**From:** [Diane Abbott](#)  
**To:** [Oaklands Farm Solar](#)  
**Subject:** Further Submissions  
**Date:** 23 October 2024 14:58:11  
**Attachments:** [Oaklands NSIP submission 30-04-24 corrected.pdf](#)  
[Comments for open hearing.pdf](#)  
[Visualisation feedback.pdf](#)

I have reviewed the Applicant's responses to the ExA Question 9.1 and have noted the following points.

## **Oakland's Solar – NSIP letter**

DRAWN BY TB	APPROVED BY IH	REVISION A	SHEET 4 of 8	DATE 02/02/2024
----------------	-------------------	---------------	-----------------	--------------------

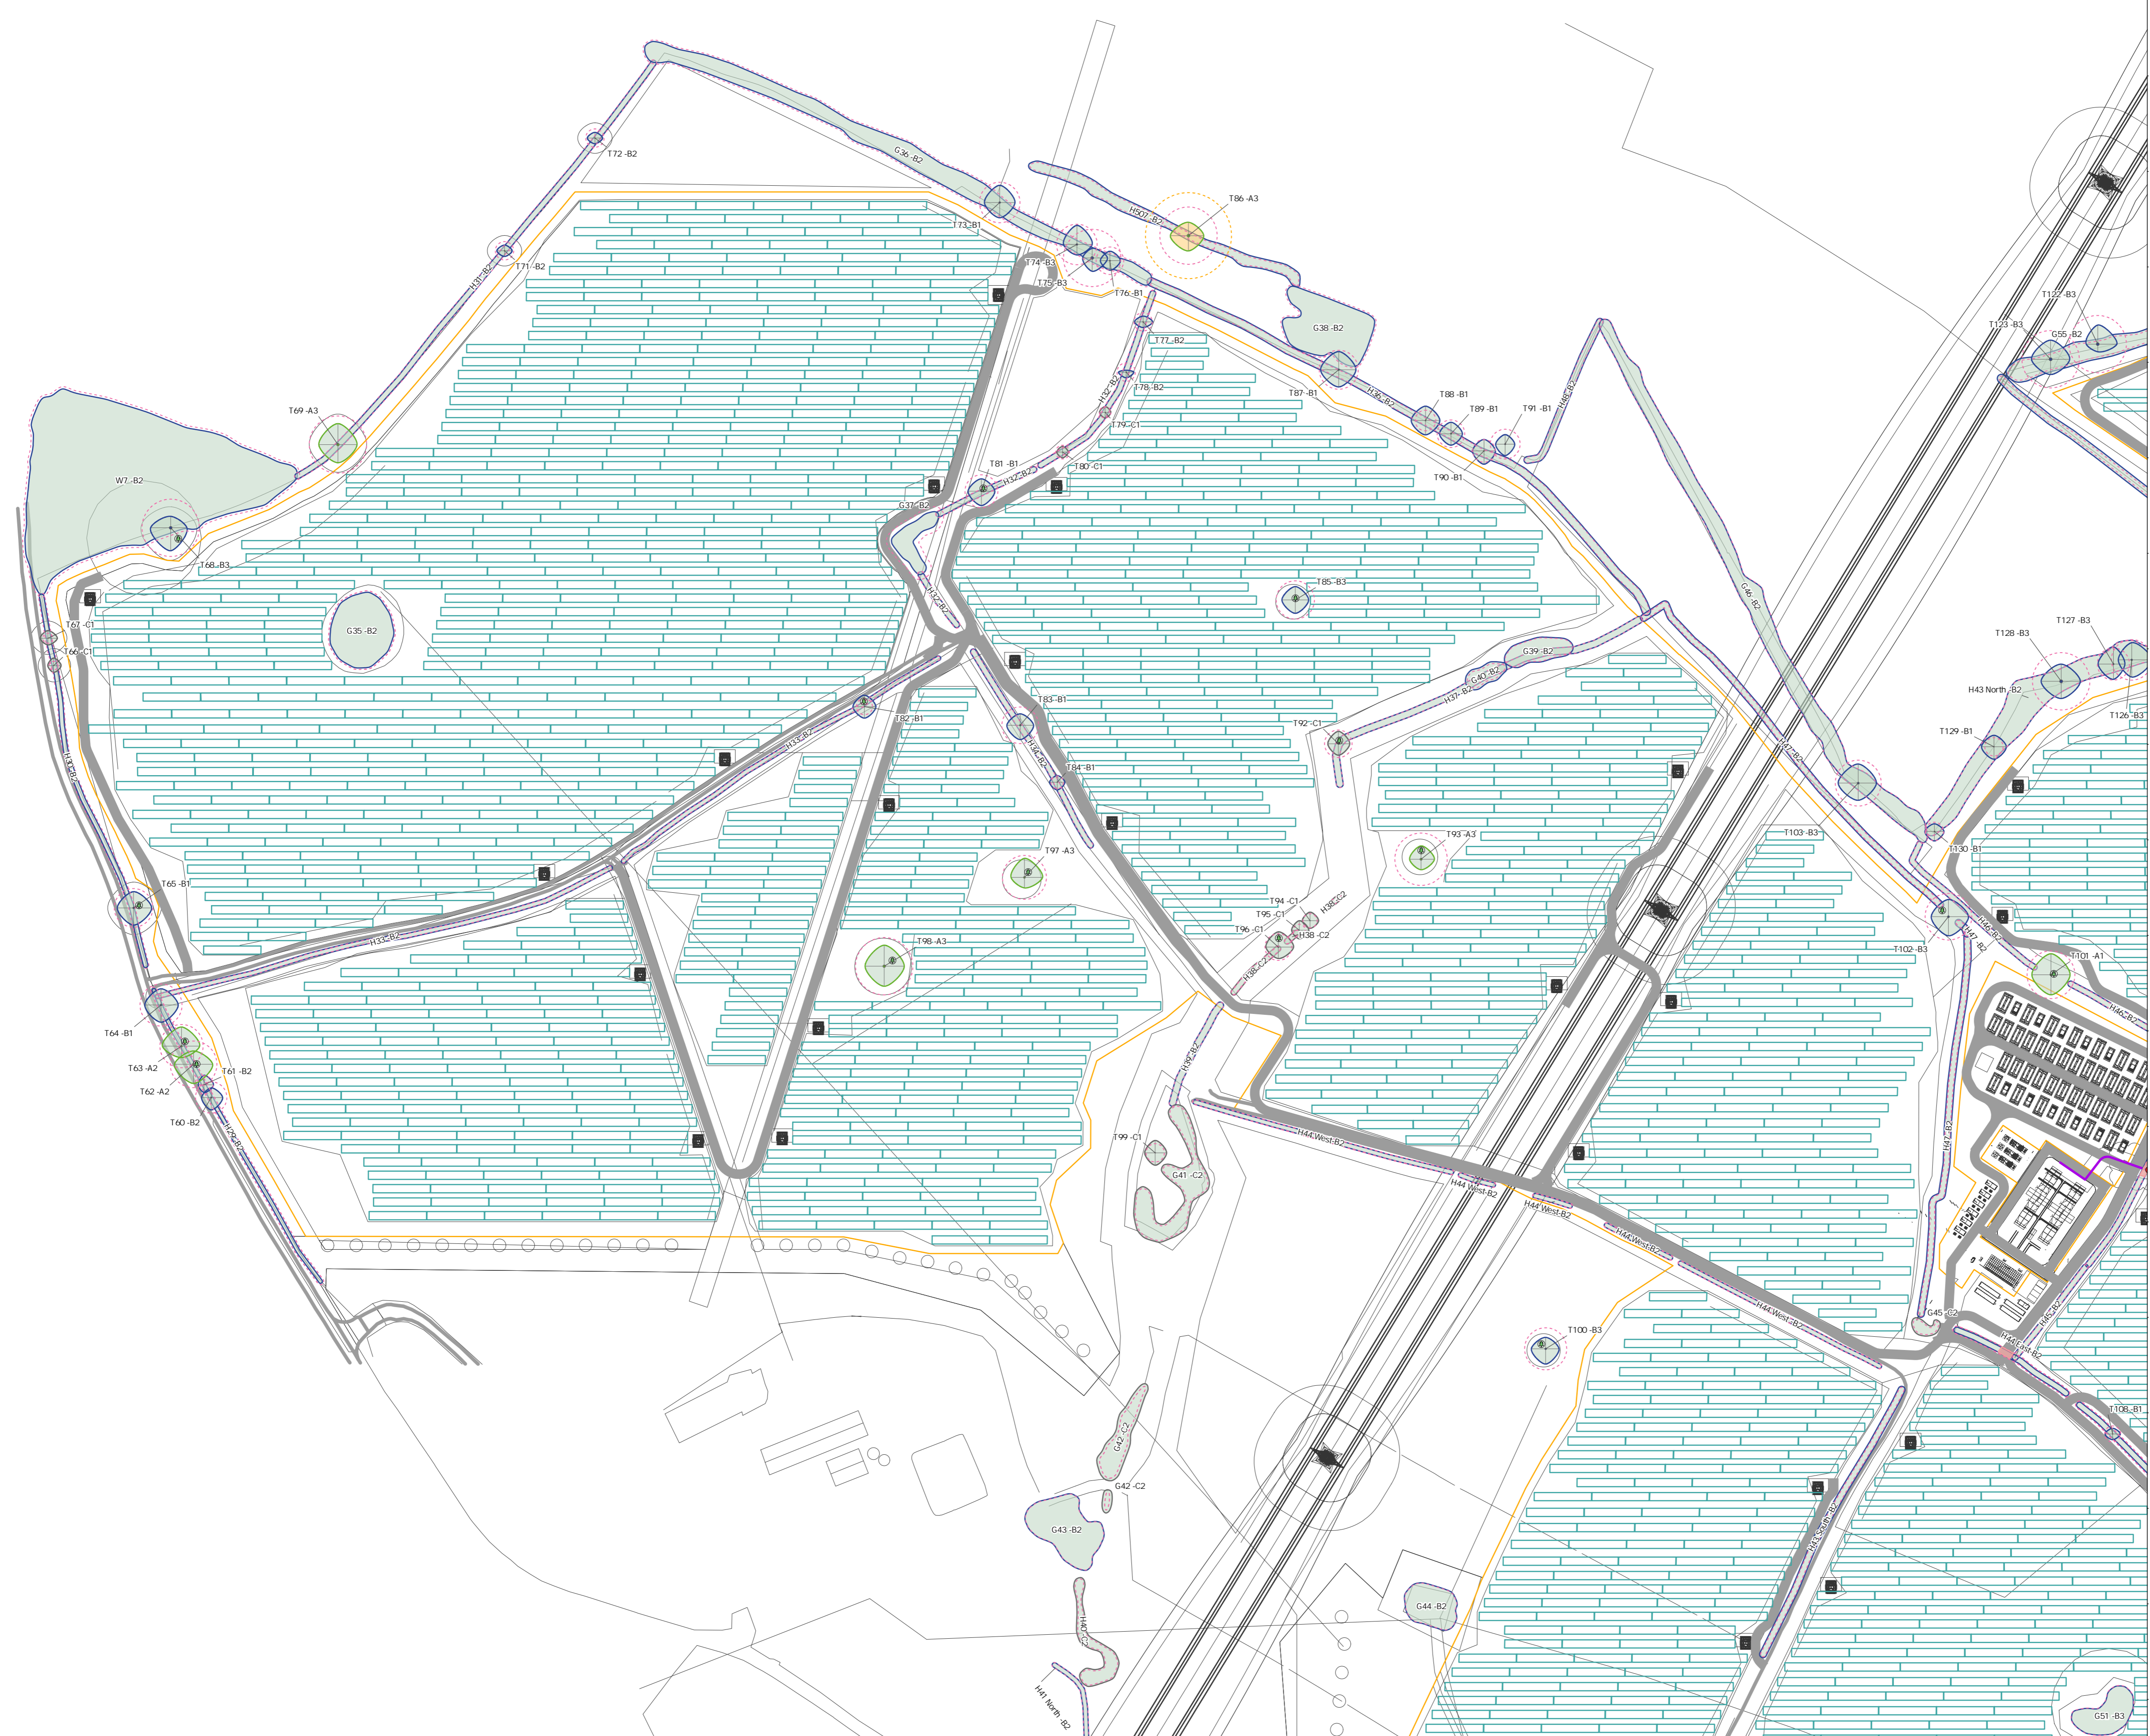
Below is an excerpt from the Arboricultural assessment EN010122/D4/6.1/Appx 6.14 (sheet 4), which shows the expected layout of the area in question. The approximate camera position and direction of view is marked in orange. (The cable route is marked in purple and security fences are yellow.)

The Applicant’s visualisation fails to show the full 6m access track running in front of the solar panels, nor does it show the security fencing that will be needed on either side of the PRow (approx. 5m between fences).

The fence and solar panels on the left side of the visualisation seem to be modelled much further away from the camera than the hedge on the right, but, as they are similar distances from the central camera position, they should show the same perspective.
